Alex Avenue Public School (SSD-9368) - Request for Additional Information

I refer to the state significant development application for the Alex Avenue Public School. After careful consideration of the Response to Submissions (RtS) submitted on 17 June 2019 and submitter comments received on the RtS (copies enclosed), the Department is requesting that you provide additional information.

1 FARMLAND DRIVE STREETSCAPE ELEVATION
1:300

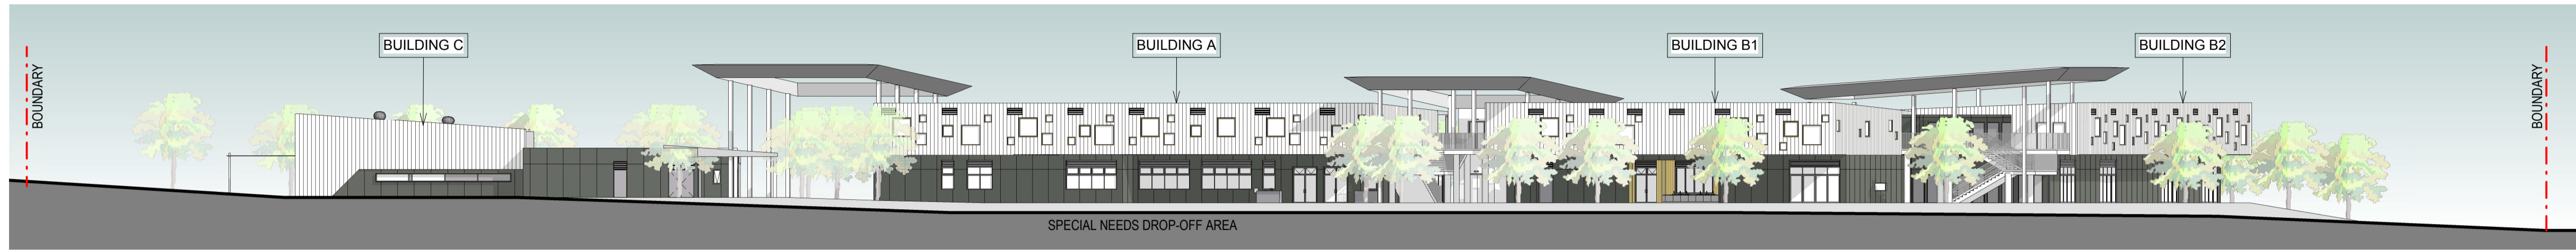
- the need for further articulation, activation and / or landscaping of the northern (Farmland Drive facing) elevation of the proposed school hall building.

OPTION 1: NO OSD REQUIRED ON SITE

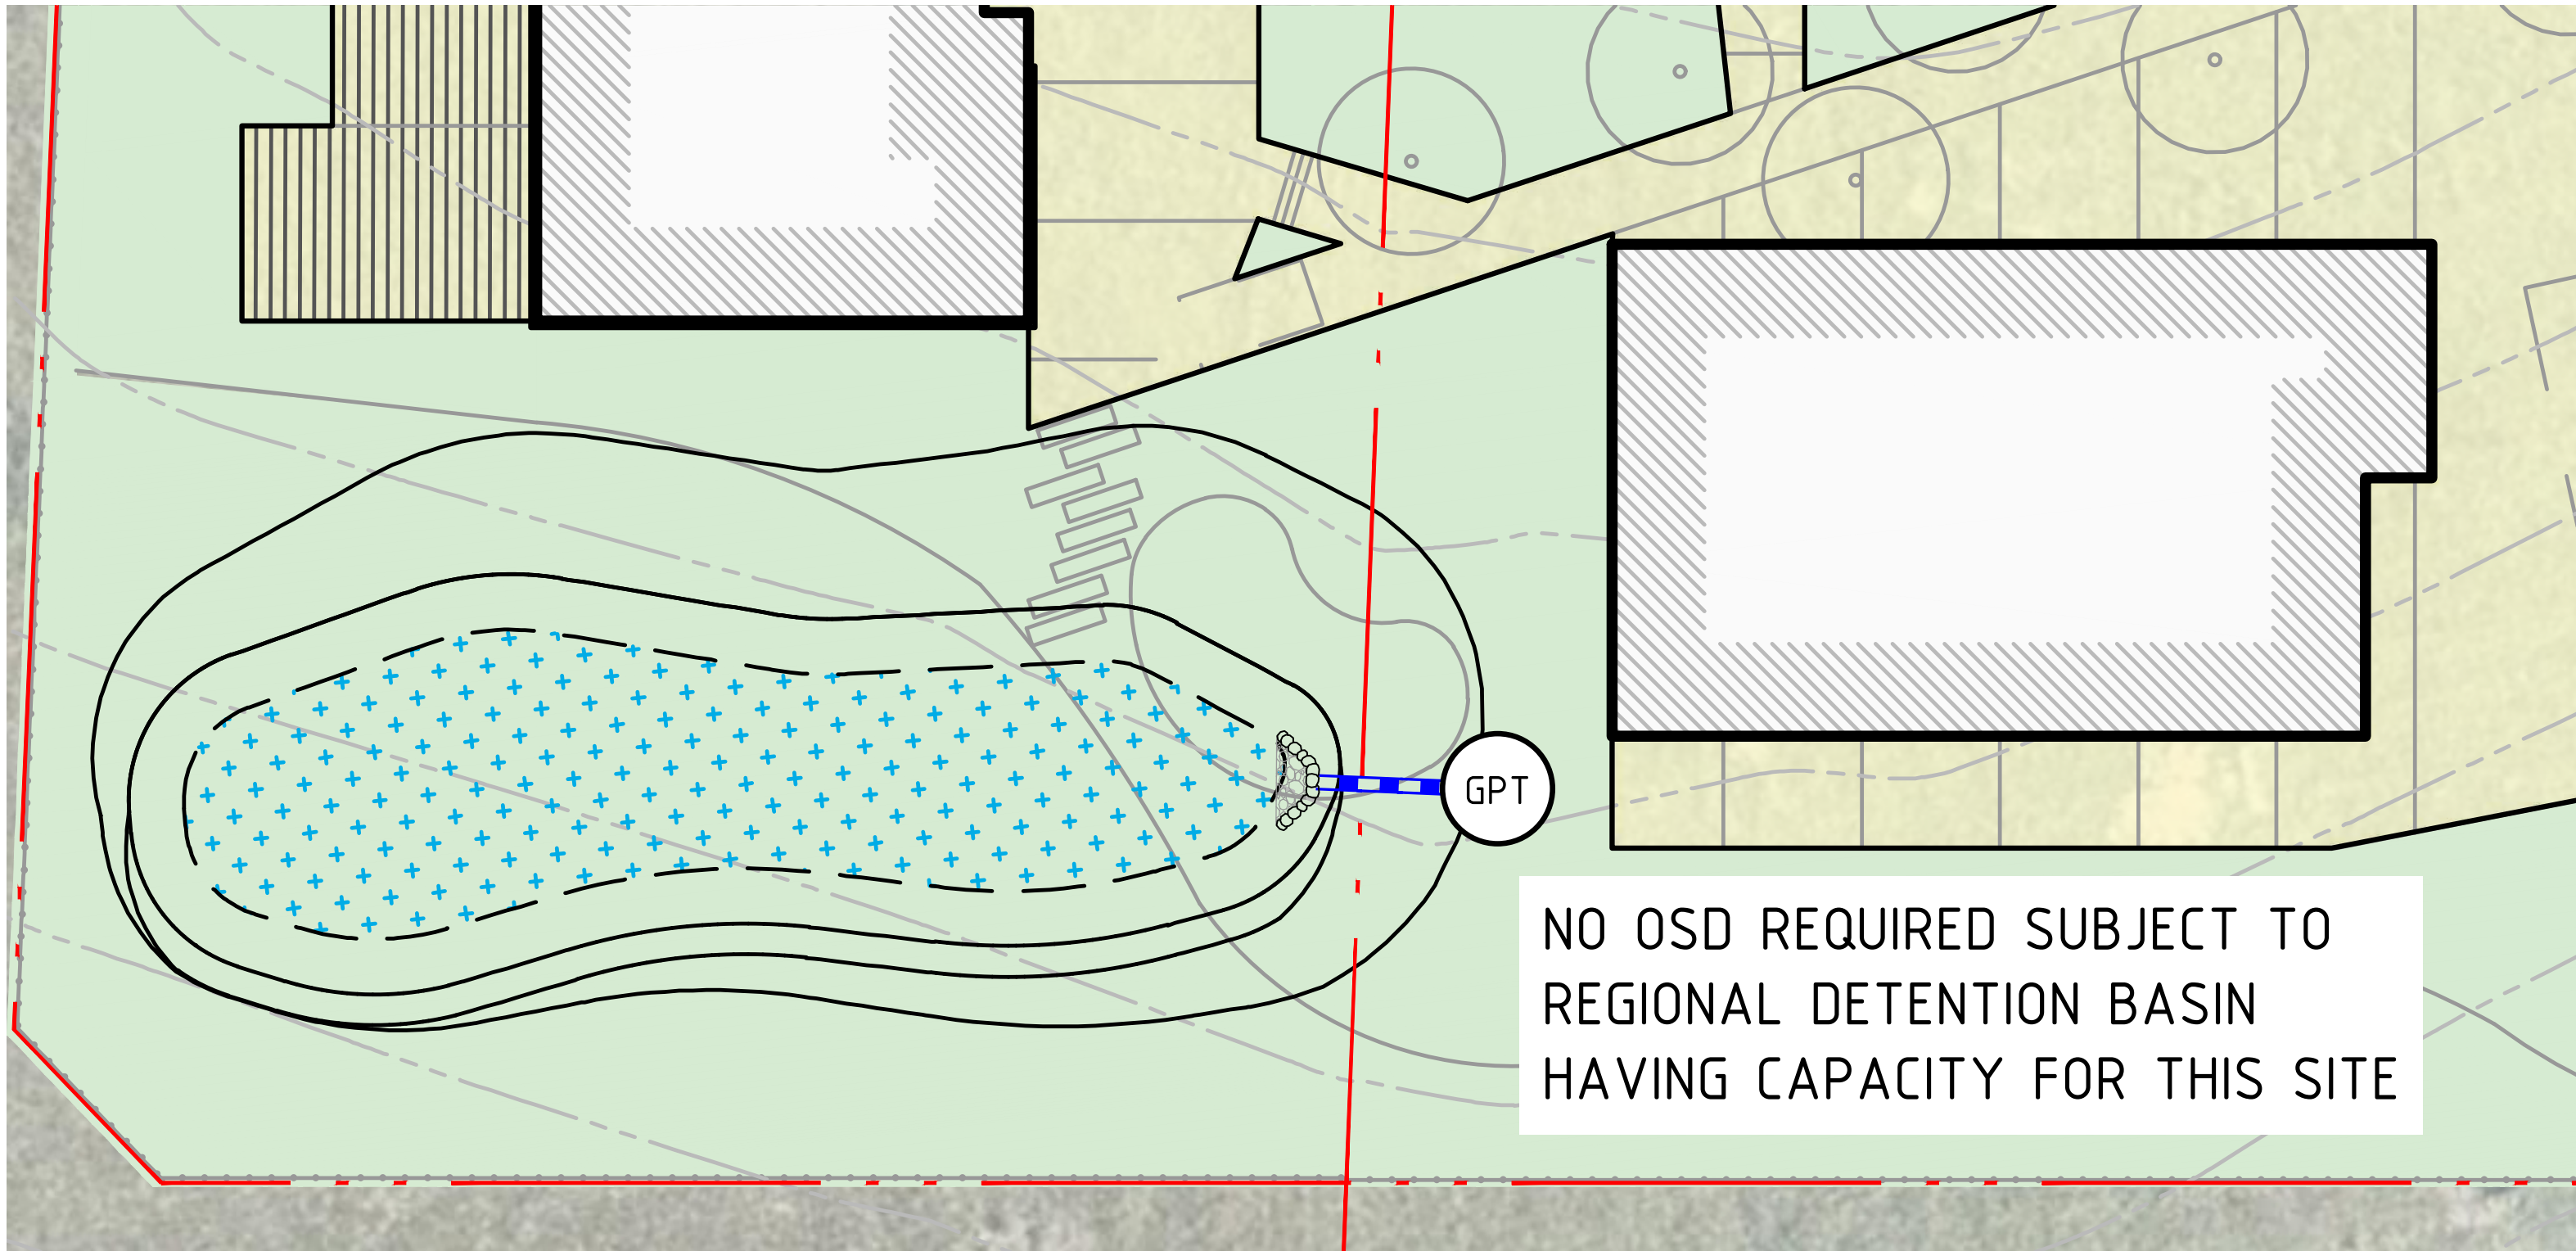
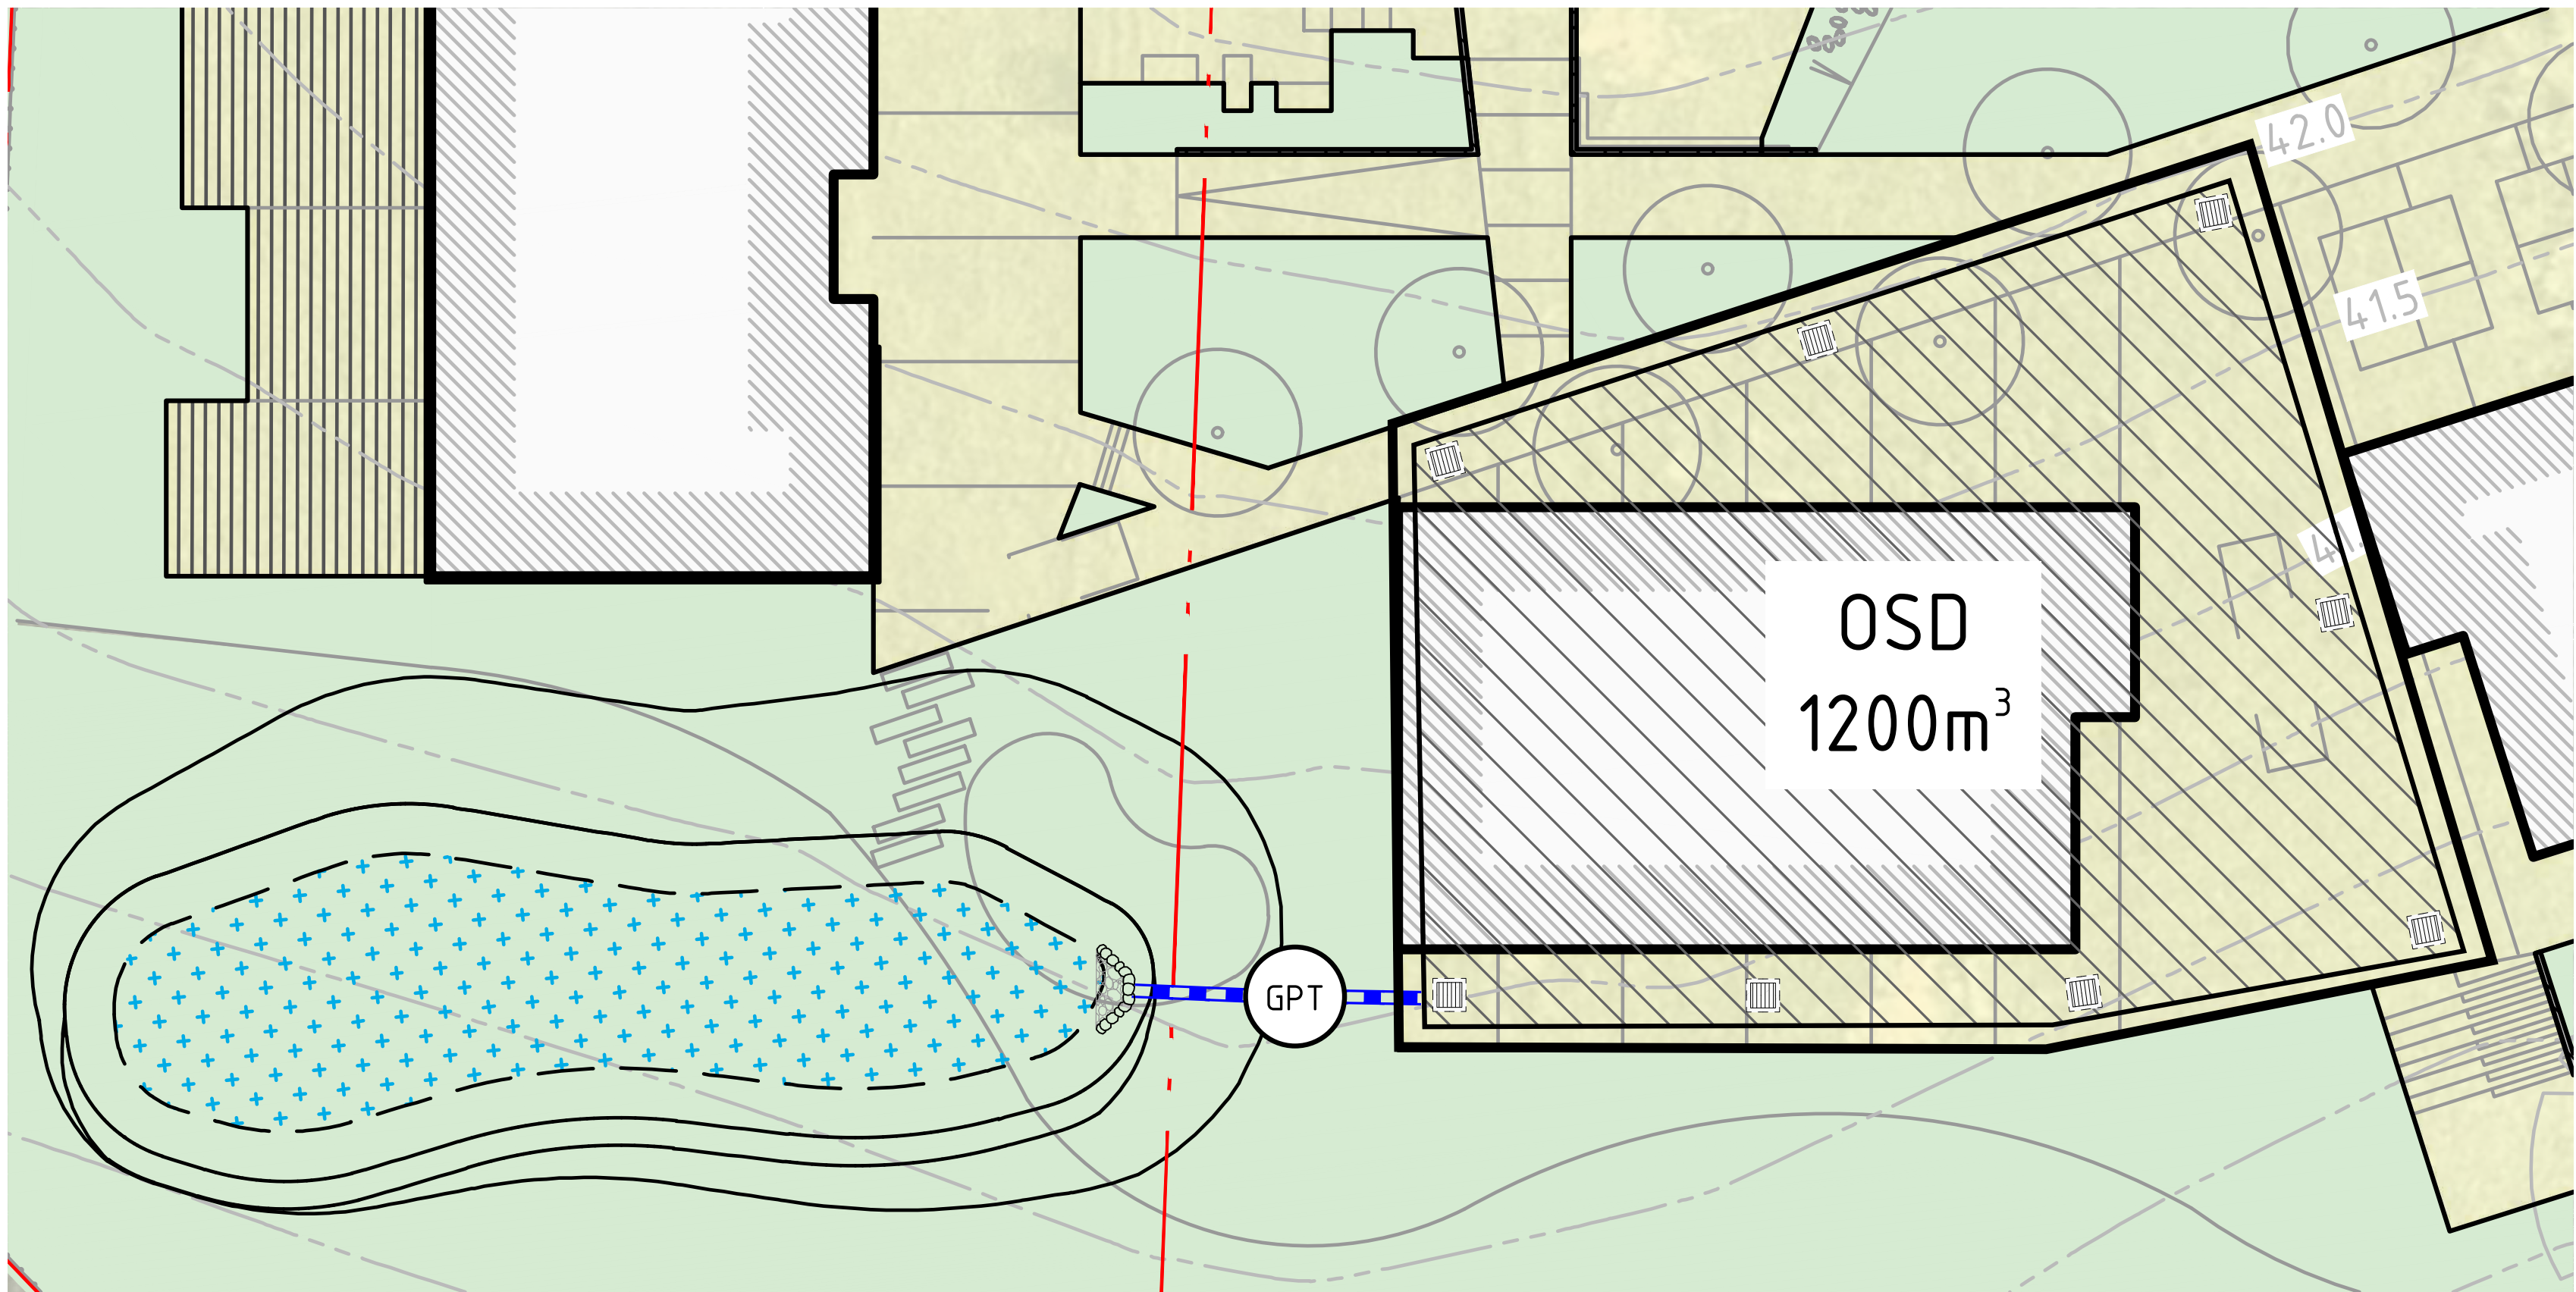
- appropriate management of stormwater drainage within, and outfall from, the site.
- consideration of potential land use conflict with the possible future extension of the school onto the southern portion of Lot 1 DP1244925 (as indicated in the RtS) and the existing access and services easement to Lot 4 DP1244925 located immediately south of the current proposed school site.
